CITY OF ALBUQUERQUE

November 20, 2014

**Re: Lot 24 Rancho Guadalupe Subdivision
Grading and Drainage Plan
Engineer's Date 10-16-14 (F13D002C)**

GRADING AND DRAINAGE PLAN

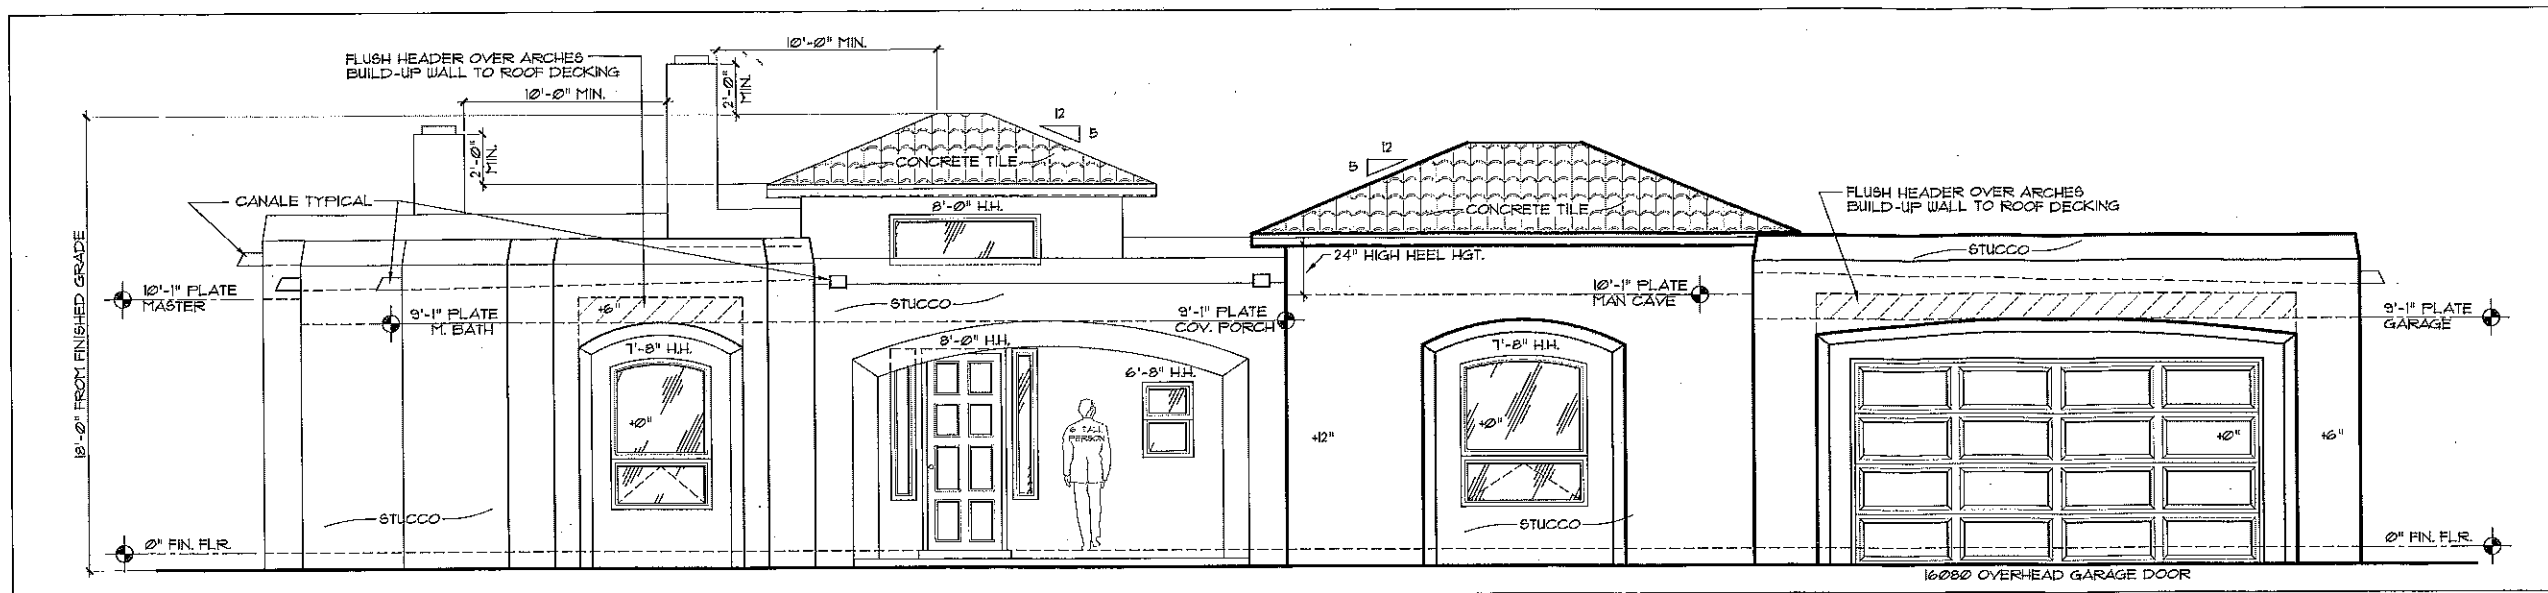
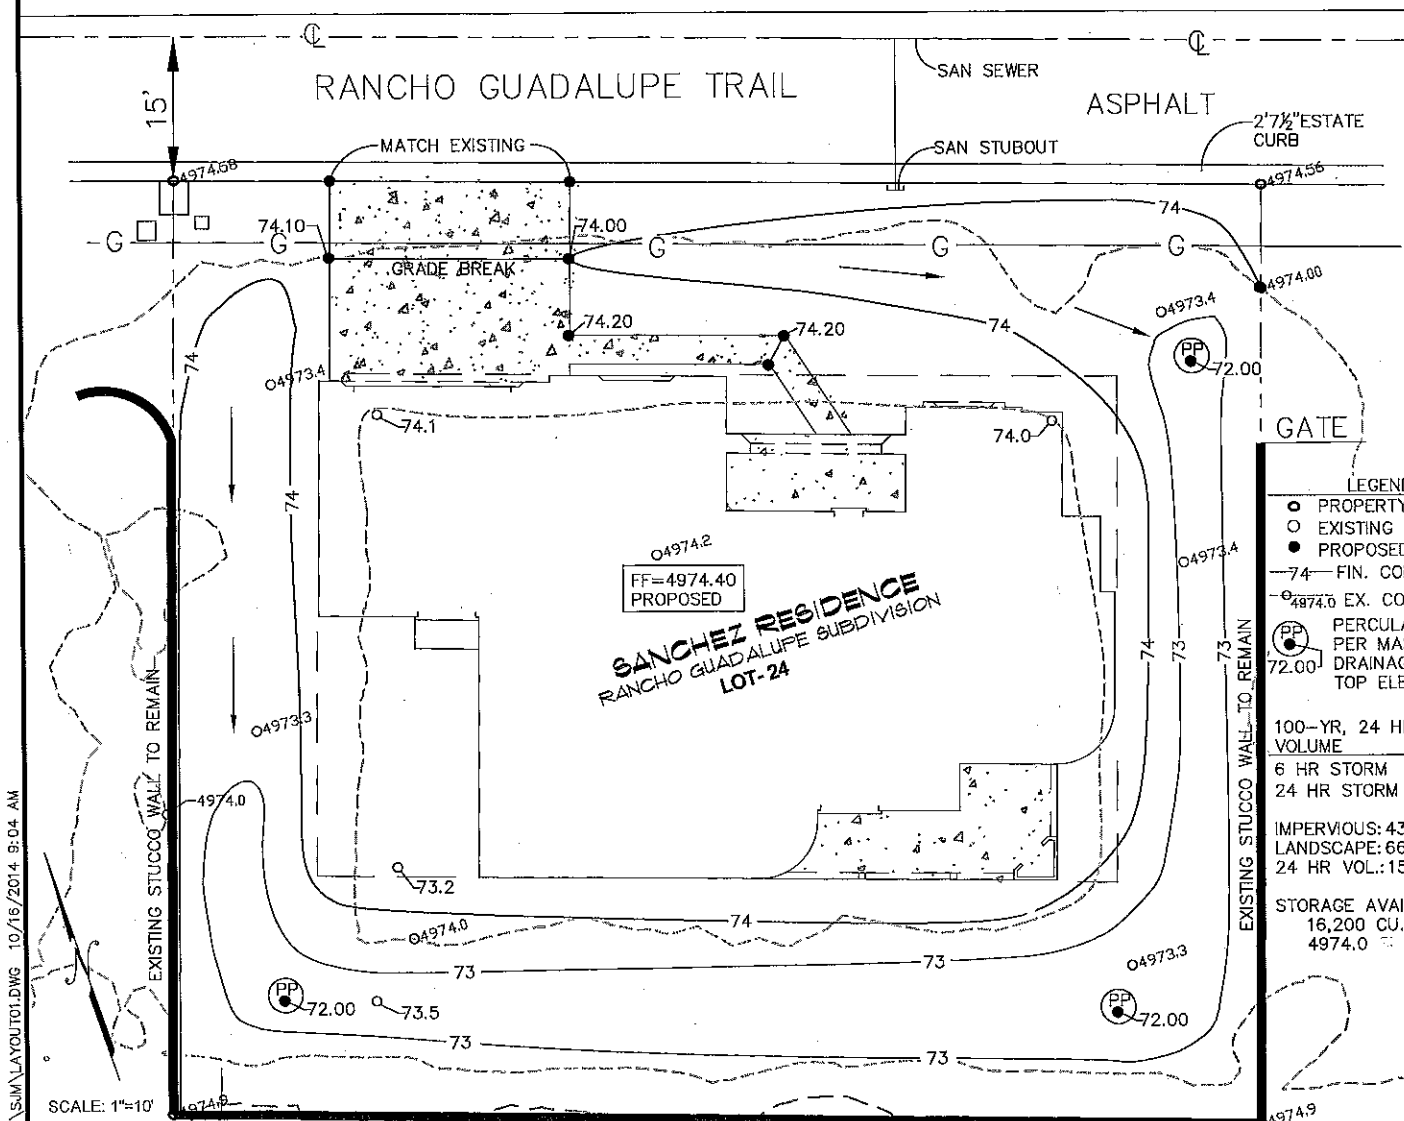
1. Provide a percolation pit detail that is per the master drainage plan. The pit should release to the sand strata.
2. The First Flush was not discussed. Per the City Drainage ordinance, the 90th Percentile Storm Event, which is 44 inches, is to be managed. Reduce 0.44 inch by the 0.1 inch for the initial impervious abstraction in Table A-6 of Section 22 of the DPM. Multiply the remaining 0.34 inch by your impervious area. This is the amount of the First Flush necessary for the site. Show that amount on your plans. State that the capacity provided by the proposed ponding is greater than what is required for the First Flush.
3. The 74 contour is not addressed in the back. Is the back wall acting as a retaining wall or is there simply a steep grade?
4. Provide a discussion of the 100 Year Flood Plain.
5. Include a site map with the site identified.
